PLANNING AMENDMENT

APPLICANT NAME AND ADDRESS South Holland District Council Priory Road Spalding Lincs PE11 2XE Telephone:		AGENT NAME AND ADDRESS S Greenfield South Holland Building Consultancy Council Offices Priory Road Spalding PE11 2XE Telephone:	
SITE ADDRESS DETAILS 13 Station Road, Moulton			
CURRENT APPLICATION NO: This amendment cannot be considered unless the relevant reference is stated.		H13-0120-20	
Building Regulation reference relating to same development (if applicable)

1 **Dropped Kerb Block Plan - (Proposed)**
1 : 200

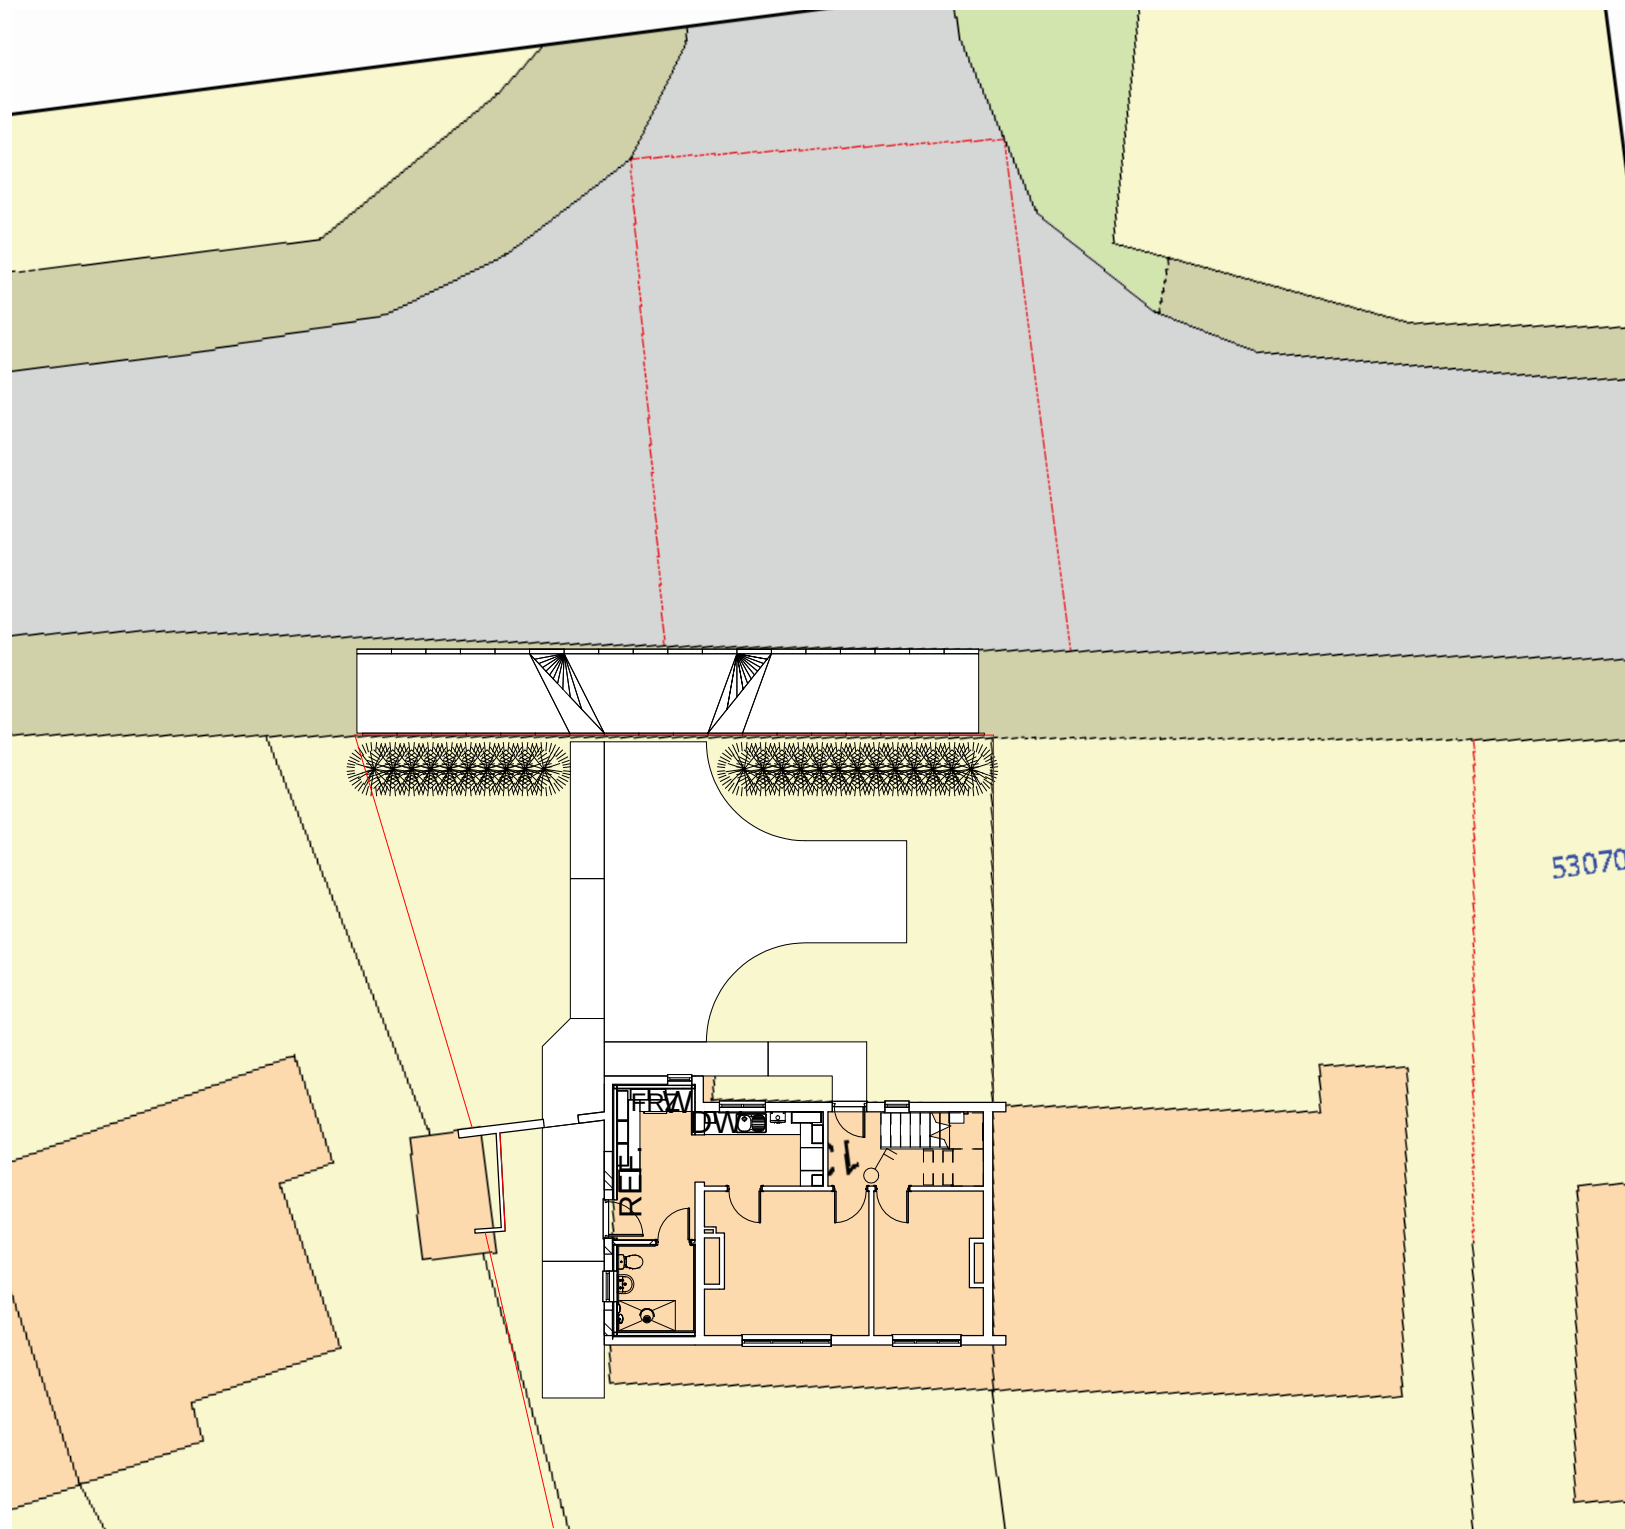
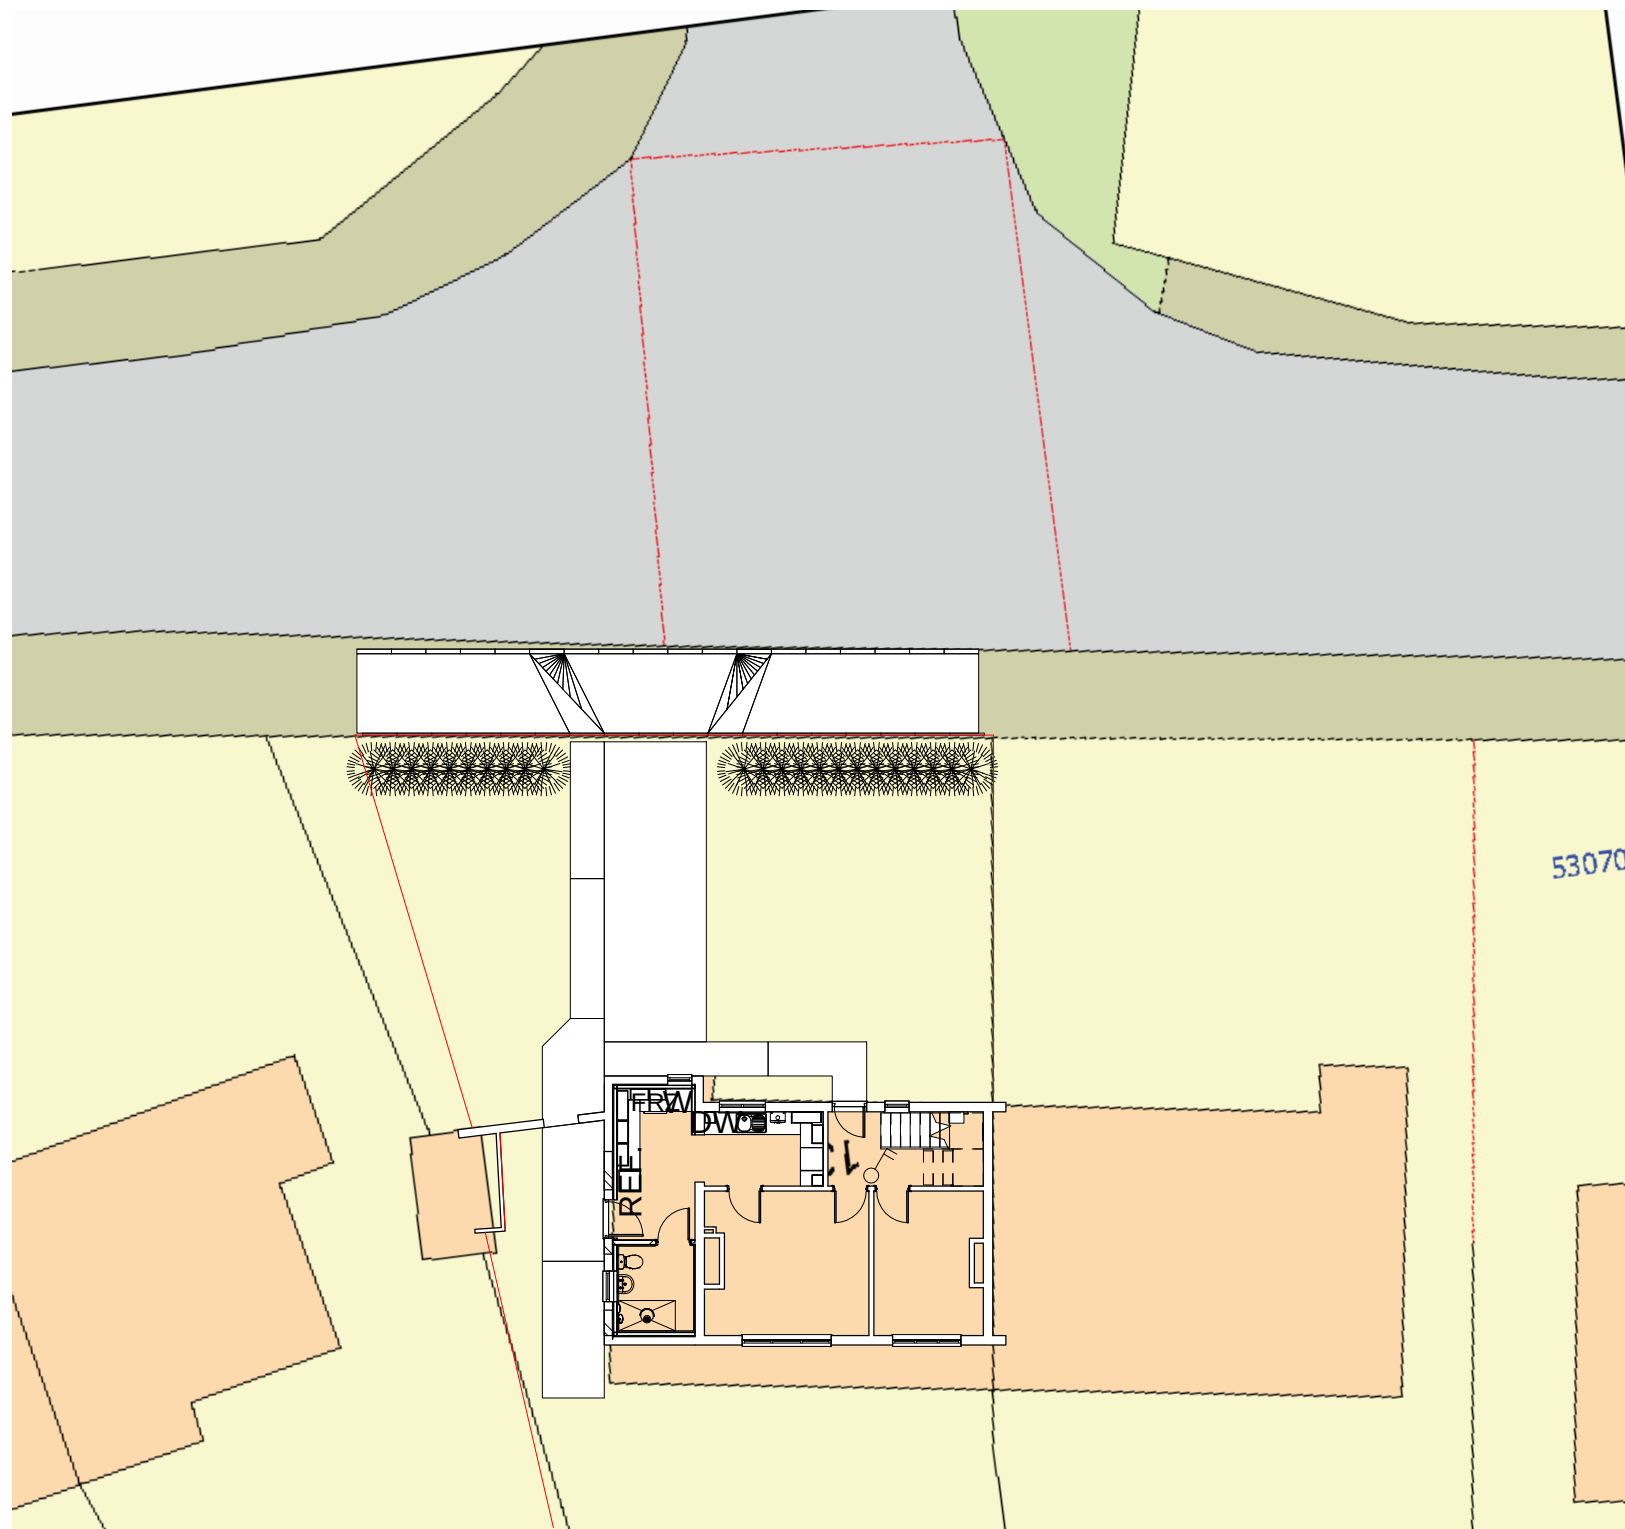
FULL DESCRIPTION OF DEVELOPMENT OF CURRENT APPLICATION THAT THIS AMENDMENT RELATES TO			
State details of amendments proposed. (Give a full detailed list of the changes, and also mark these clearly on the accompanying plans. Only the changes listed here will be considered)		Turning head added within dwelling curtilage	
State drawing numbers of the current submission		103A; 105A	
Has this amendment been requested by the Council? (If so, state Officer dealing with the application)		YES/NO	Maria Salemme
Describe any part of the original development which is excluded by virtue of the amendment, and state any alteration to plot numbers			
Has a similar amendment been submitted under Building Regulations? (If so, state Building Control Surveyor dealing with application)		YES/NO
